Development & Commercial Stormwater Construction Site Inspection Report

General Information			
Project Name	Valle De Atrisco Apartments		
Owners/Operators Name	DBG properties, LLC. for Valle De Atrisco, LLP.		
Date of Inspection	08/02/19	Start Time	13:50
Inspector's Name(s)	Jeff D. Hart		
Inspector's Title(s)	Inspector.		
Inspector's Contact Information	Jeffdh@inspectionsplusinc.com		
Inspector's Qualifications	Training and work experience – see inspector qualification page in section 2 of the SWPPP.		
Type of Inspection: <input checked="" type="checkbox"/> Regular <input type="checkbox"/> During storm event <input checked="" type="checkbox"/> Post-storm event			
Weather Information			
Has there been a storm event since the last inspection? Yes If yes, provide: Storm Start Date: 07/29/19 Approximate Amount of Precipitation (in): 0.15"			
Weather at time of this inspection? <input type="checkbox"/> Clear <input type="checkbox"/> Cloudy <input type="checkbox"/> Rain <input type="checkbox"/> Sleet <input type="checkbox"/> Snowing <input type="checkbox"/> High Winds <input checked="" type="checkbox"/> Partly Cloudy <input type="checkbox"/> Other:

Project: DBG for Valle De Atrisco Apa

VALLE DE ATRISCO
EROSION & SEDIMENT CONTROL PLAN

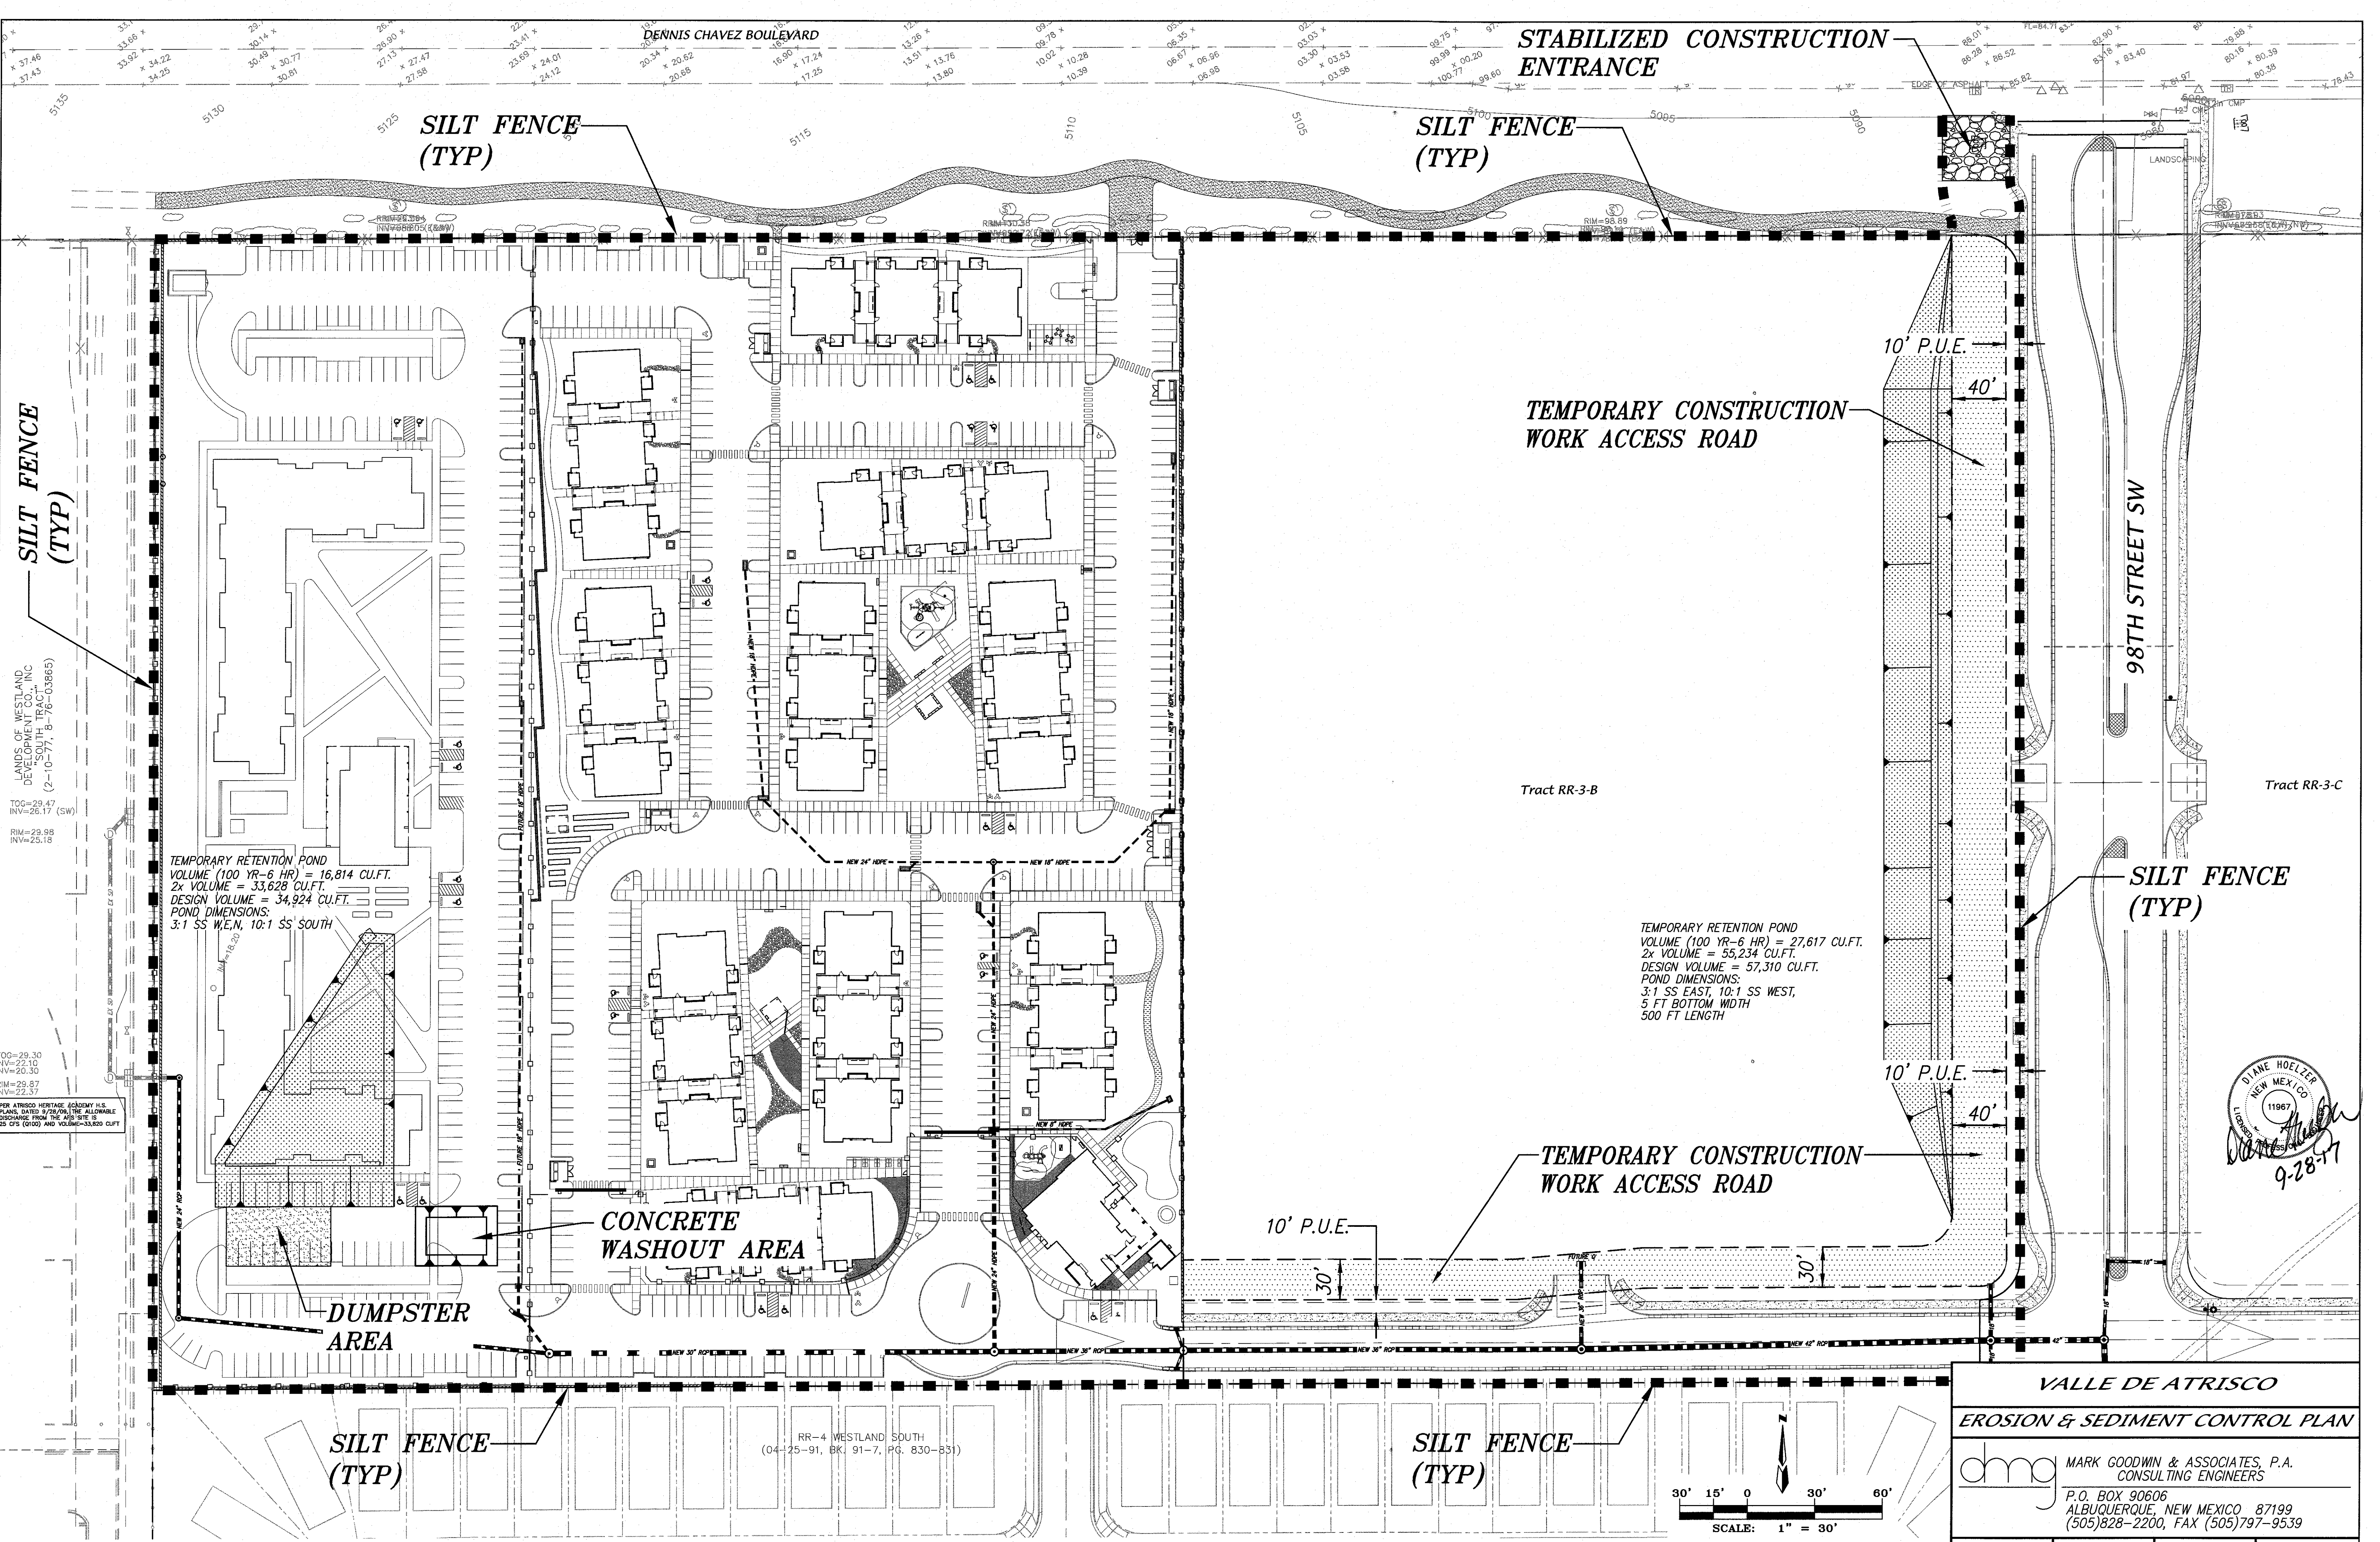
Notes	
1. Remove built up sediment from the inlet BMP fabric protection. Maintain cut back around the inlet, or provide wattles, when complete.	
2.	
3.
